Your Ref: OWPC23060
Our Ref: K/9/19/HH 18-03-2019
Please ask for:
Zac Denton

Replacement of existing studio building, adjacent to house, with new studio building, to be used as extension to house. This application may affect the setting of a listed building.

Kingston Corner Brookside Road Kingston

Ref: Planning Application: K/9/19/HH Kingston Corner

Drawing Title:
3D VIEWS 1

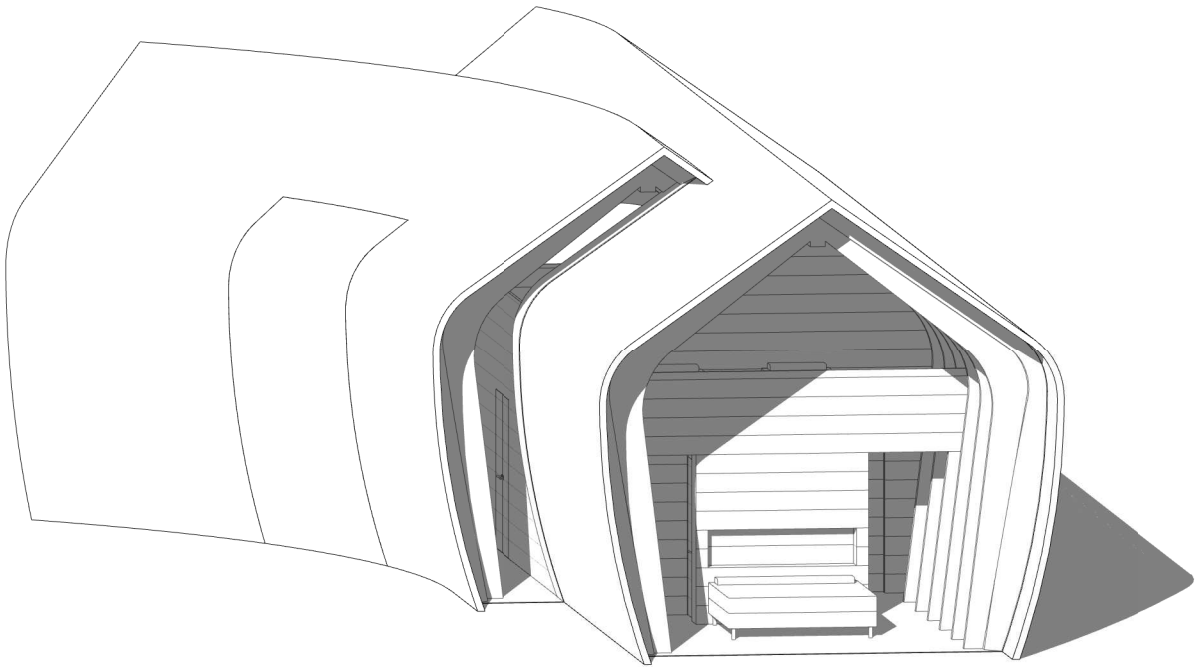
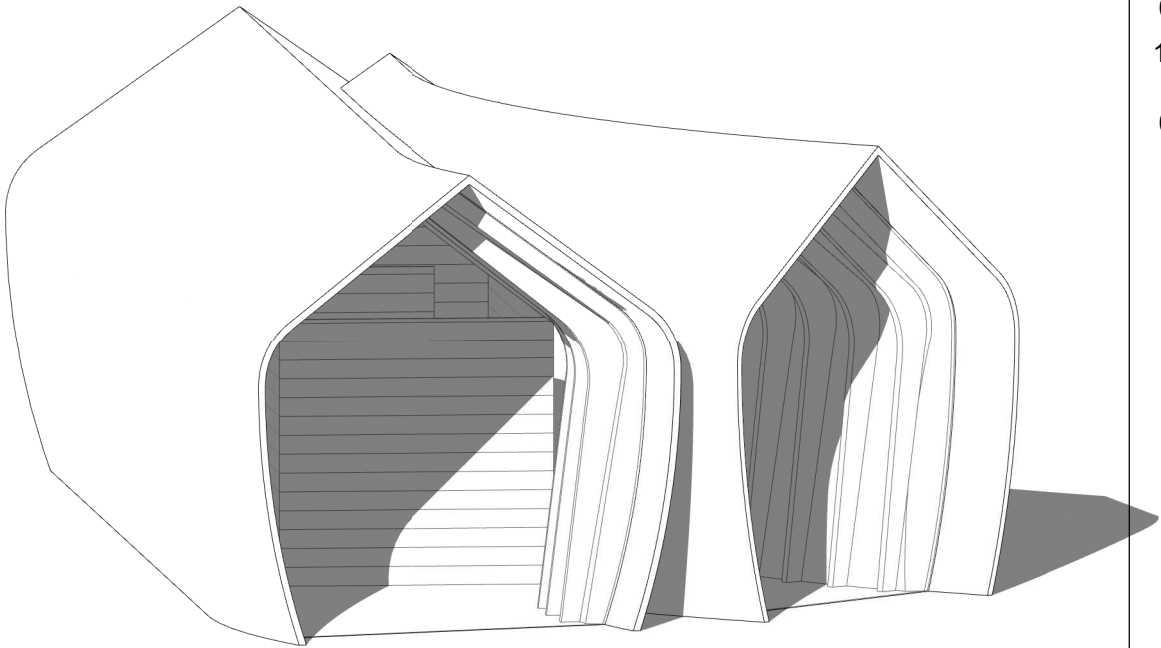
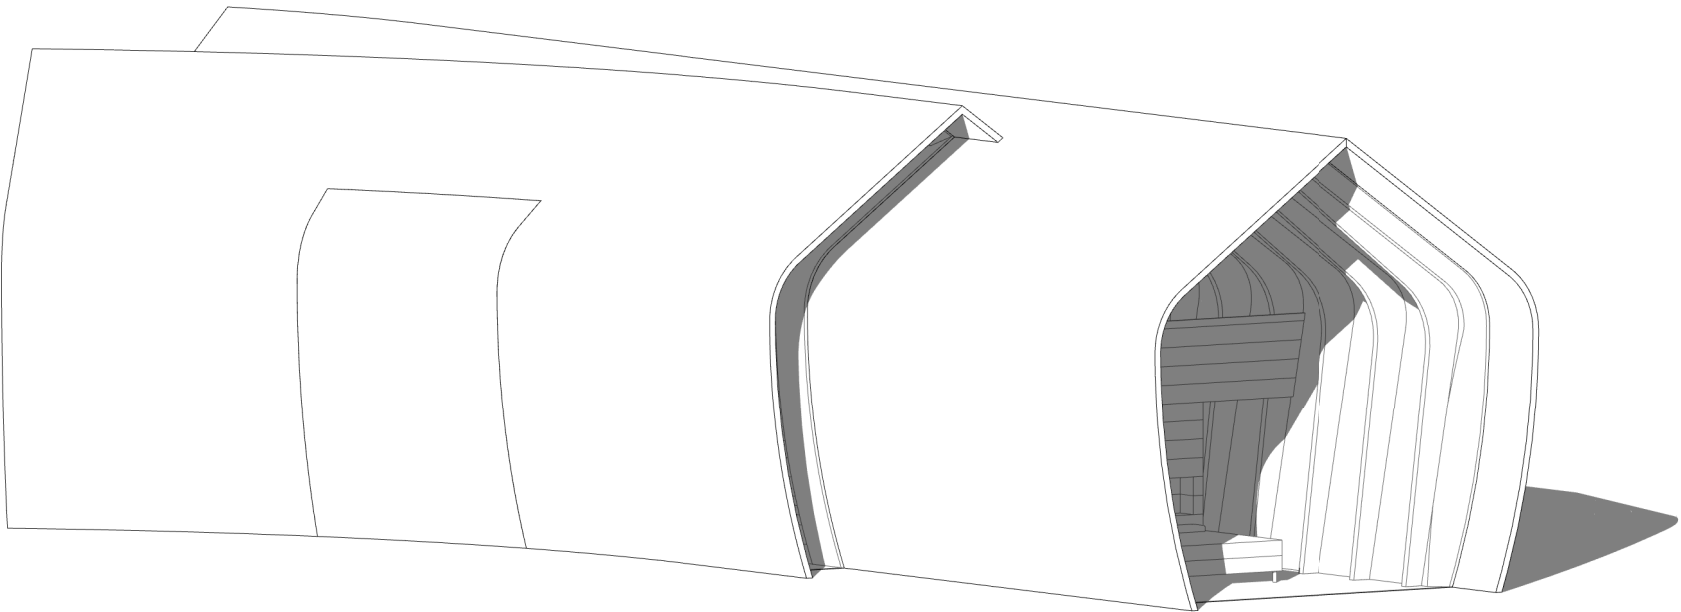
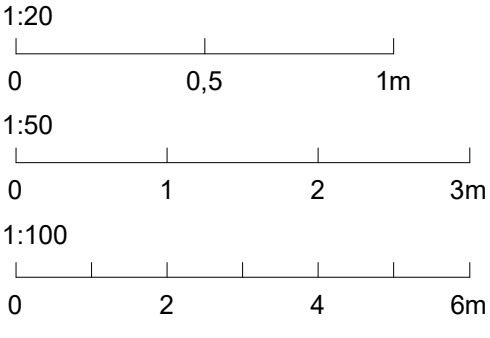
- 1. The development is not appropriate and sympathetic to the character of the Kingston Gorse Estate and its surrounding properties and the appearance in terms of building materials (corten steel) and design features is out of character with its surroundings.*
- 2. The proposed development is not in scale with adjacent buildings. The current outbuilding that is being replaced by this development has a footprint of 34m whilst the new development is almost four times as big with a footprint of 129m . The proposal also goes beyond the existing building to the front of the property, bringing it closer to the road.*
